**From:** [REDACTED]  
**Sent:** 22 September 2021 14:05  
**To:** Planning  
**Subject:** Application Reference 3/2021/0686: FAO Ben Taylor

The proposals will comprise a significant two storey rear and side extension. [REDACTED] is two storey and during the course of the determination of our application, officers took care to ensure that the plots on our site were sited to achieve a minimum 21m interface distance [REDACTED]. This was deemed important due to the change in levels between the properties.

Drawing Title  
Proposed Plans and Elevations

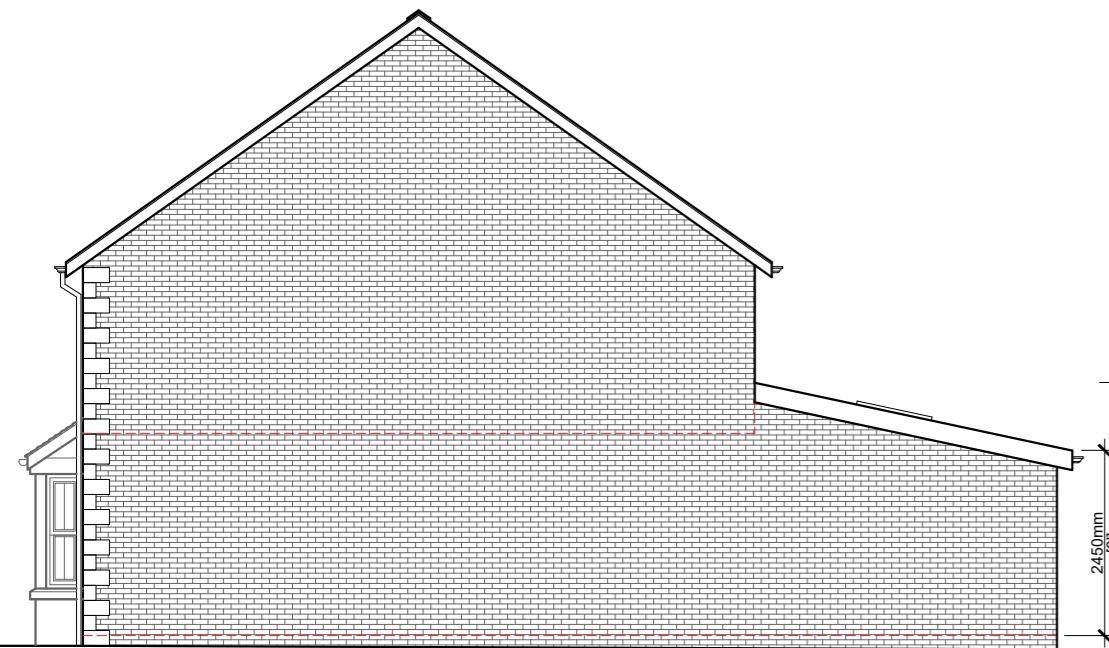
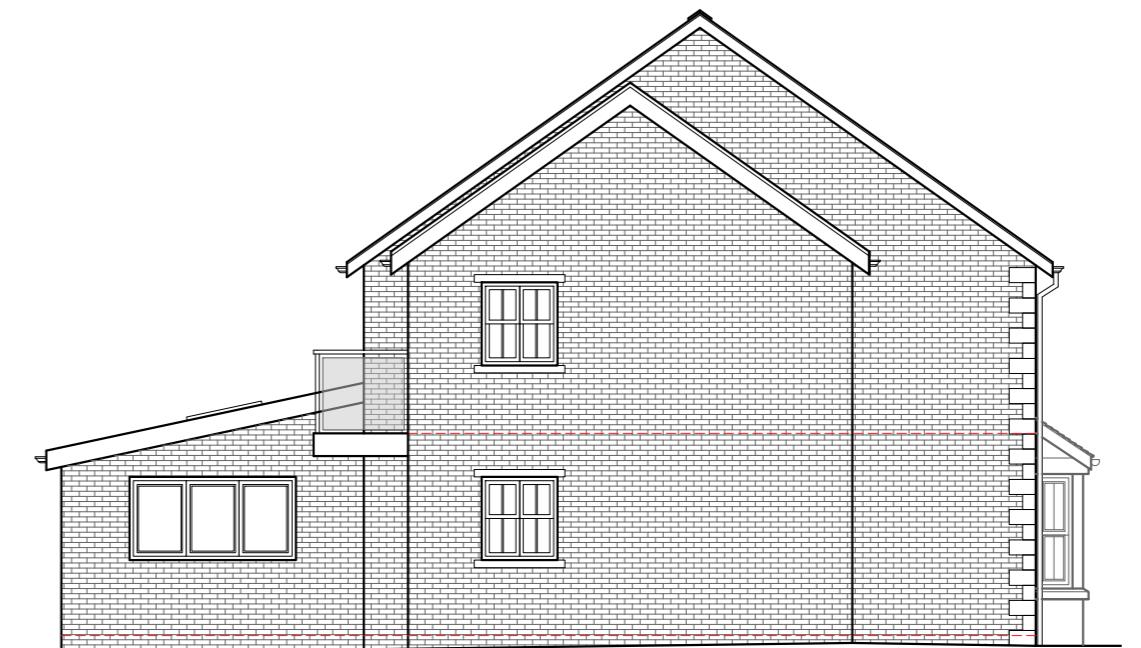
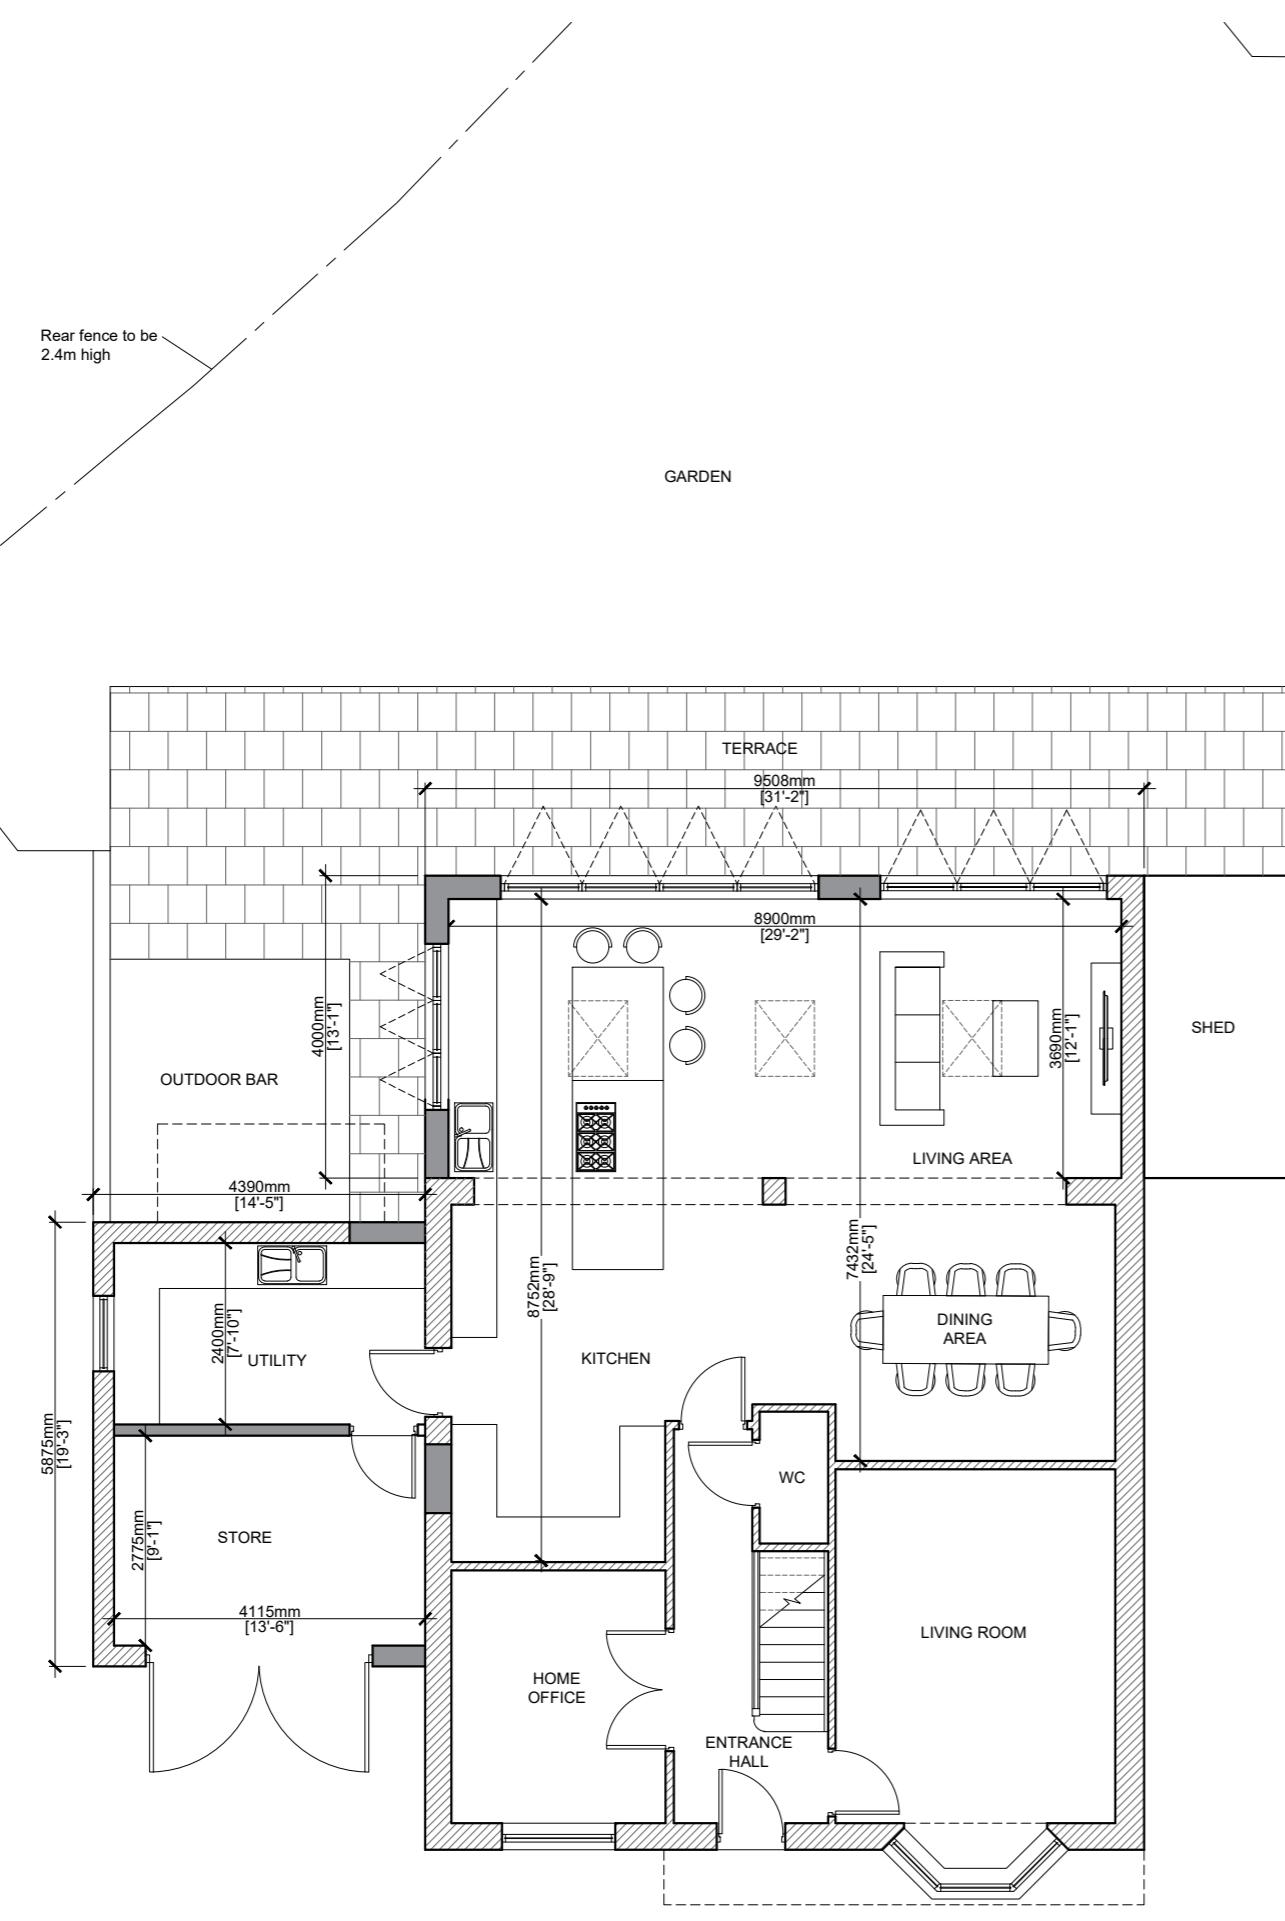
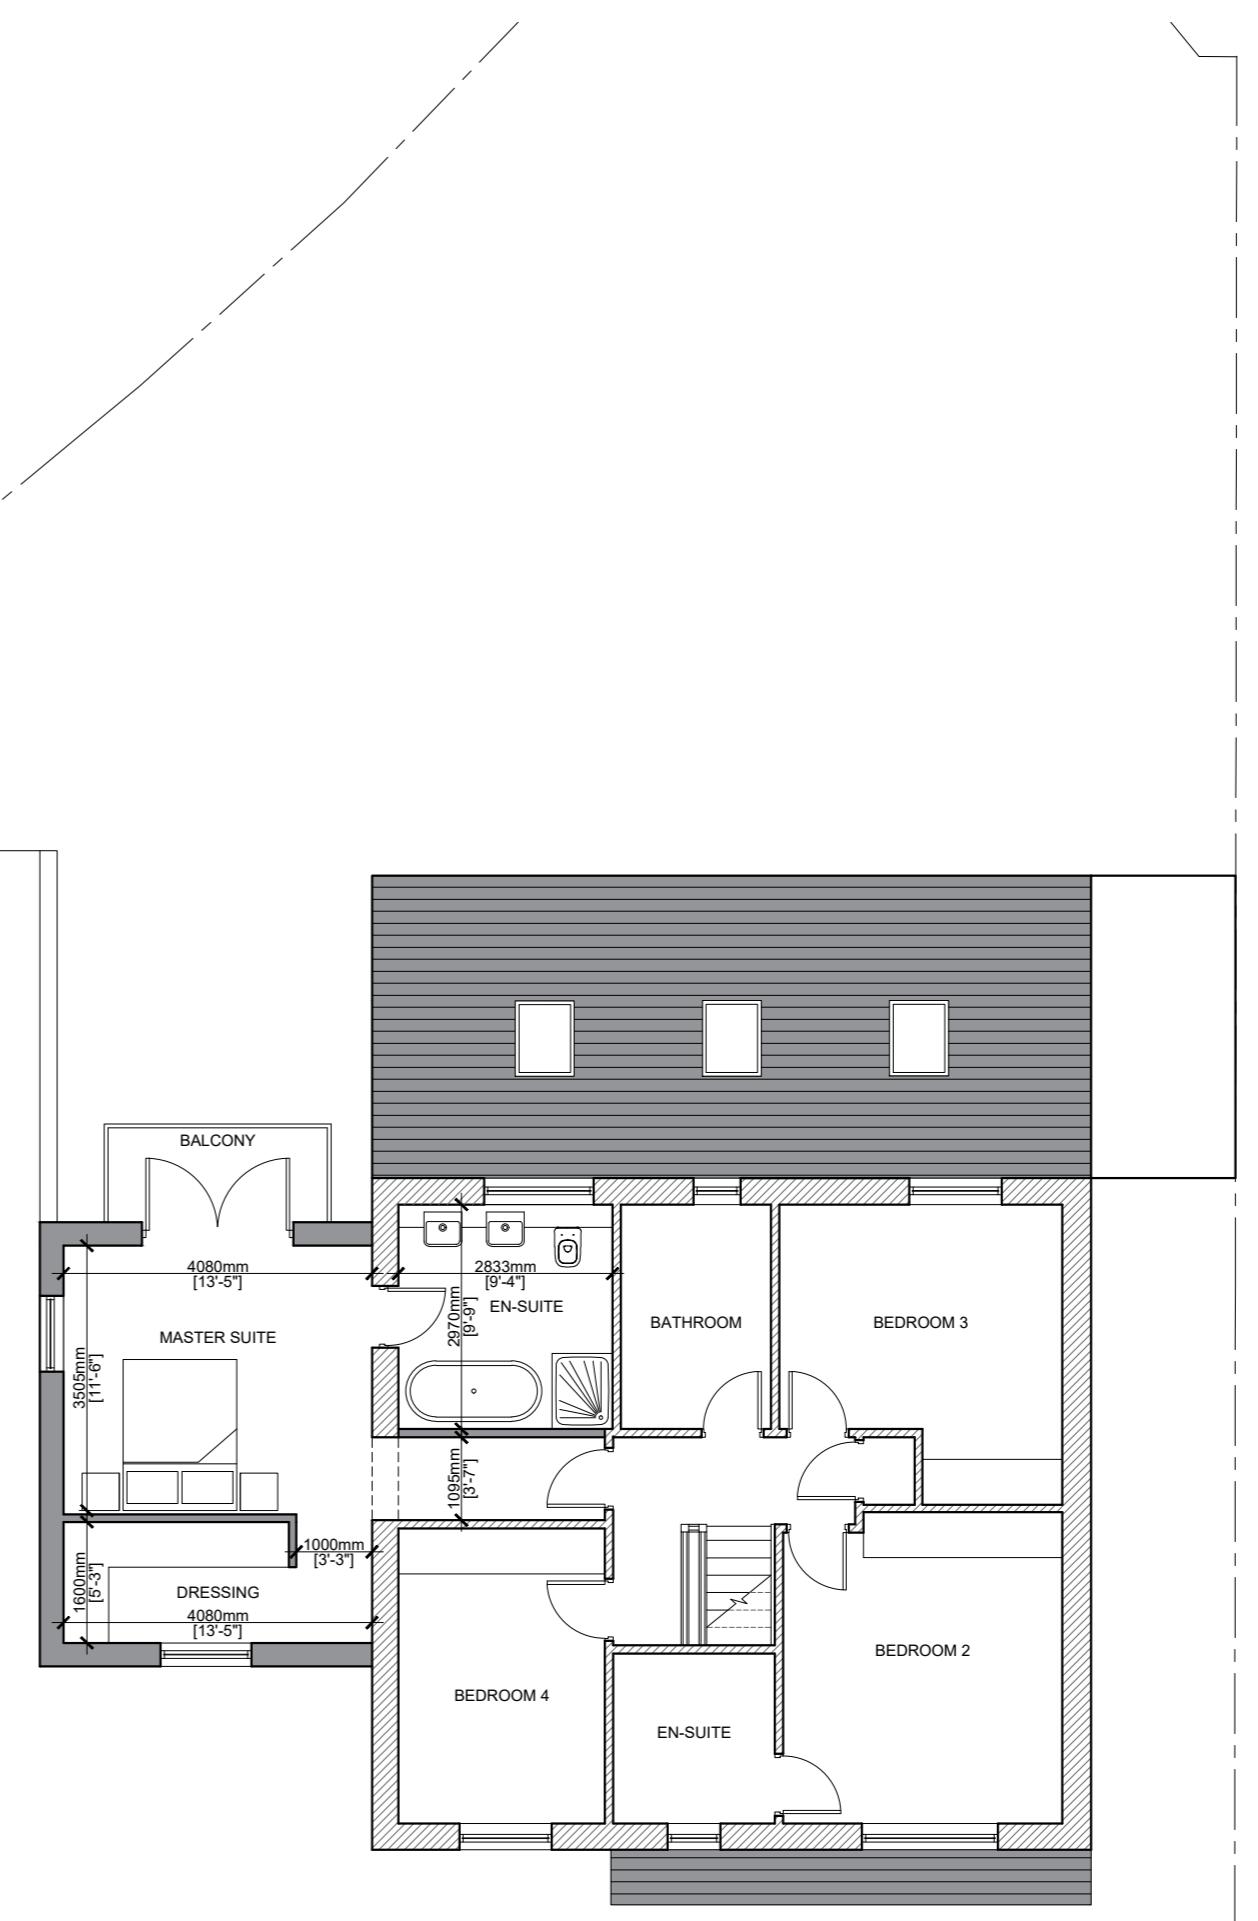
We note that the application submitted has not included any information on interface distances to the above properties, despite that information being freely available. The proposals will result in additional two storey development situated closer to the properties on our site and it will have an unacceptable and overbearing impact on our future residents. Officers will be aware of the recent application to remove the dying ash trees that were once on this boundary, which will only serve to exacerbate this effect.

Further we note that the proposals include a fully balcony to the rear. Were this to be permitted, it would allow full and uninterrupted overlooking over the rear private amenity space, and also straight into principal habitable rooms of each of those properties, unacceptably harming privacy.

Whilst a somewhat aged document, the Council's Planning Guidance for Extensions and Alterations To Dwellings makes clear the 21m interface distance should be followed, except in special circumstances. No special circumstances have been demonstrated. Further it states, "*Balconies should be sited or screened so as not to cause loss of privacy to neighbours.*" The proposal to provide 2.5m high fencing on the boundary with our properties would do nothing to ameliorate the impact.
